From: Carol Reynolds
Sent: 17 November 2017 12:17
To: Planning.Responses
Cc: Anita Gardner
Subject: FW: Planning Consultation on: EP/133/17/PD

APPLICATION EP/133/17/PD

Site Address: 126-128 Sea Road East Preston

Description of Works: Application for Prior Notification under Class C for change of use from shop (A1) to Cafe/Restaurant (A3)

PROPOSED

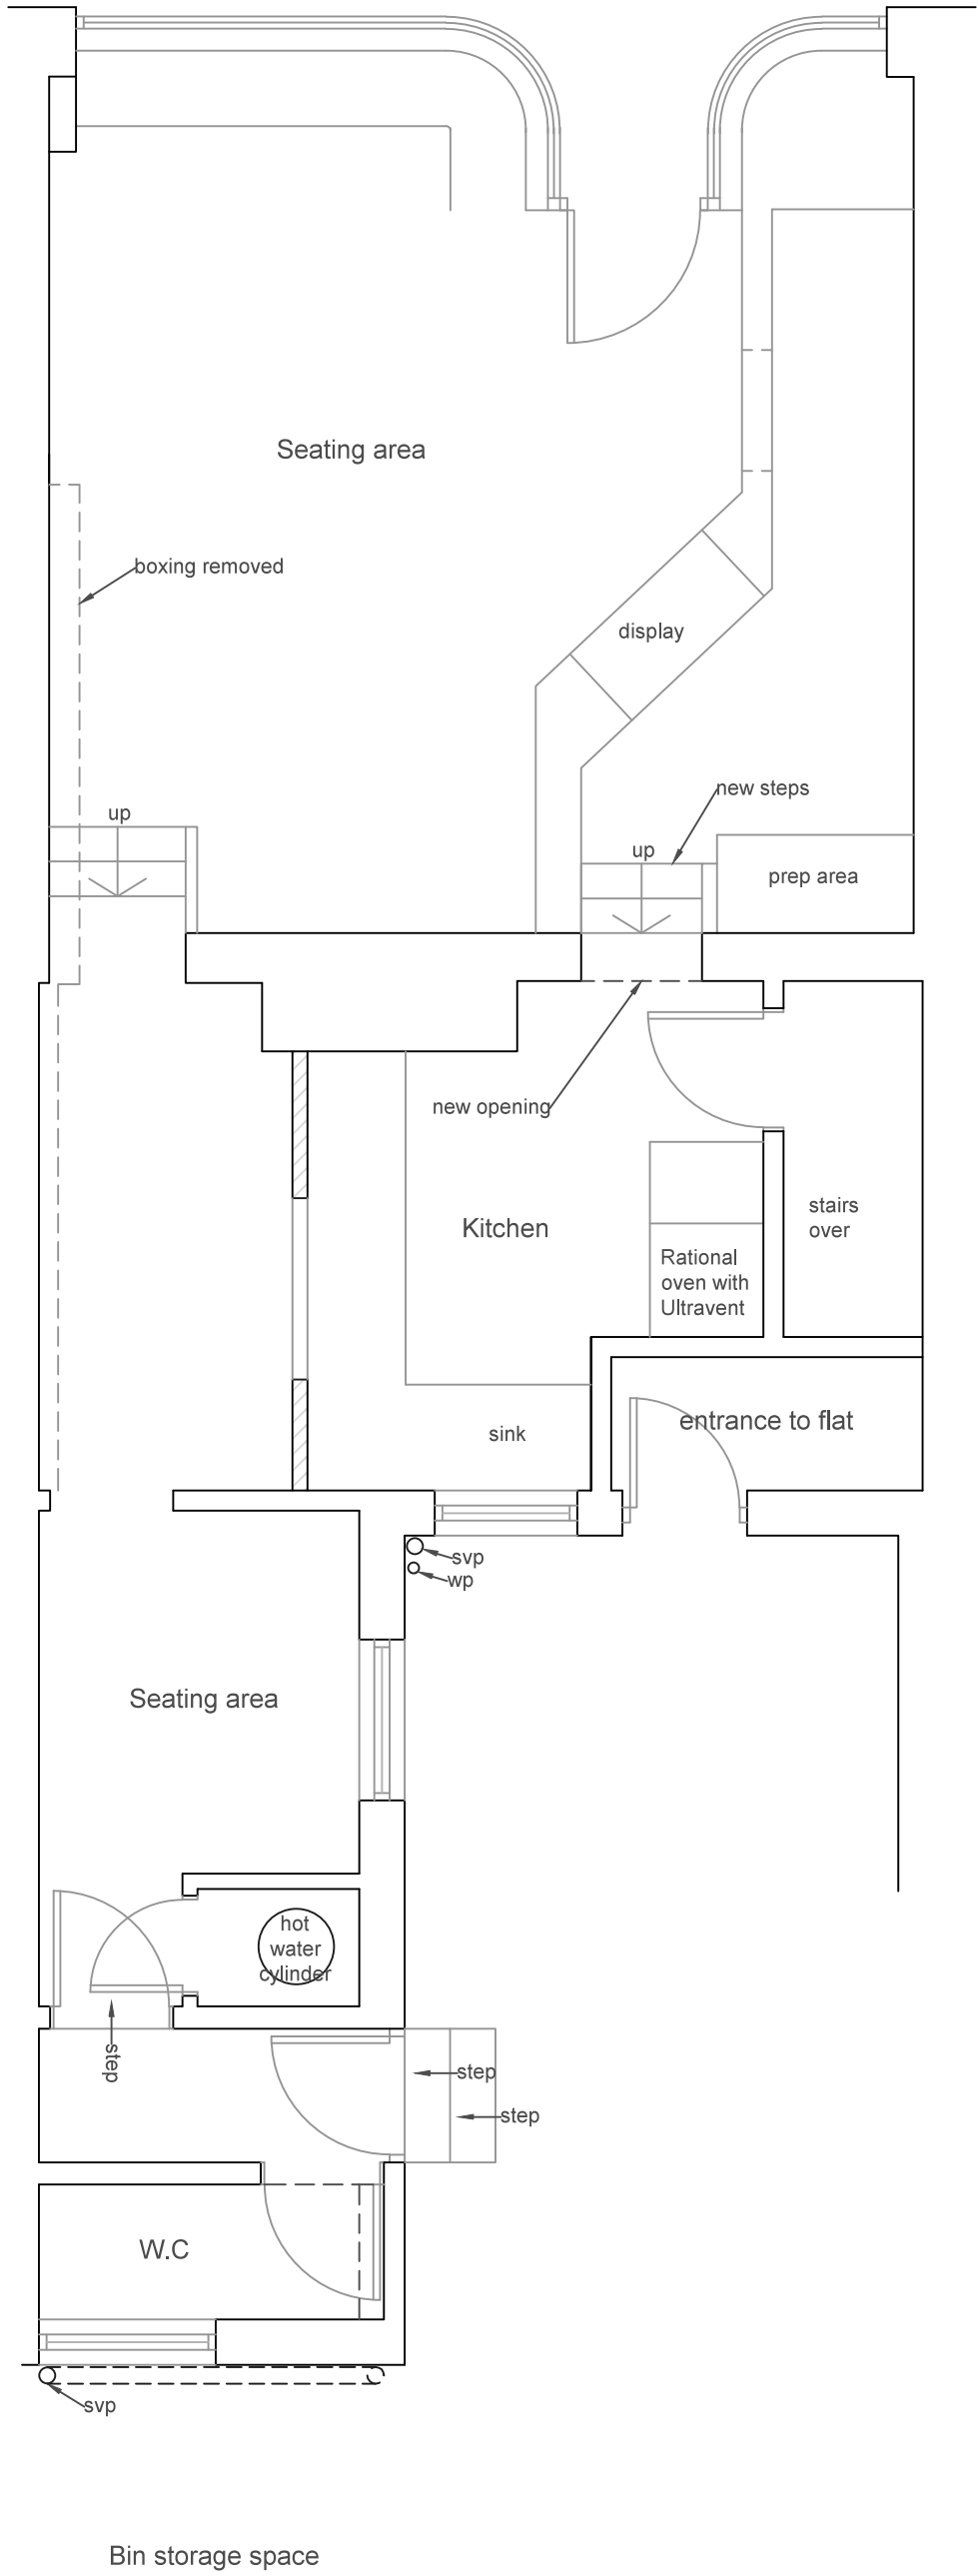
It is proposed to change this premises to A3, café/restaurant use. The suggestion of a recirculating fan to condense fumes/cooking odours to be disposed of via the drain is unacceptable to this Department. Should the Planning Department be minded to allow this application, then detail of a proper system of mechanical ventilation which incorporates suitable odour abatement must be provided. This to be accompanied by an Acoustic Report to predict noise levels from any such apparatus at the nearest sensitive location, ie overhead residential units and mitigation required to prevent detriment to the amenity. Such a mechanical means of means of ventilation, odour abatement and noise mitigation to be agreed by the Environmental Health Department before development goes ahead.

The space allocated for kitchen use would appear to be small, further restricted by an overhead staircase here. I have concerns for how a double bowl sink and wash hand basin together with adequate storage and preparation surfaces will be provided. The intervening space to the WC will not be acceptable as a storage space for items used in the kitchen. A sink and wash hand basin will be necessary to the servery dependant on the type of food operations carried out here.

Sanitary Accommodation. Separate staff sanitary accommodation is preferred. The current provision of one WC and wash hand basin, is acceptable for up to 20 clients (male and female)
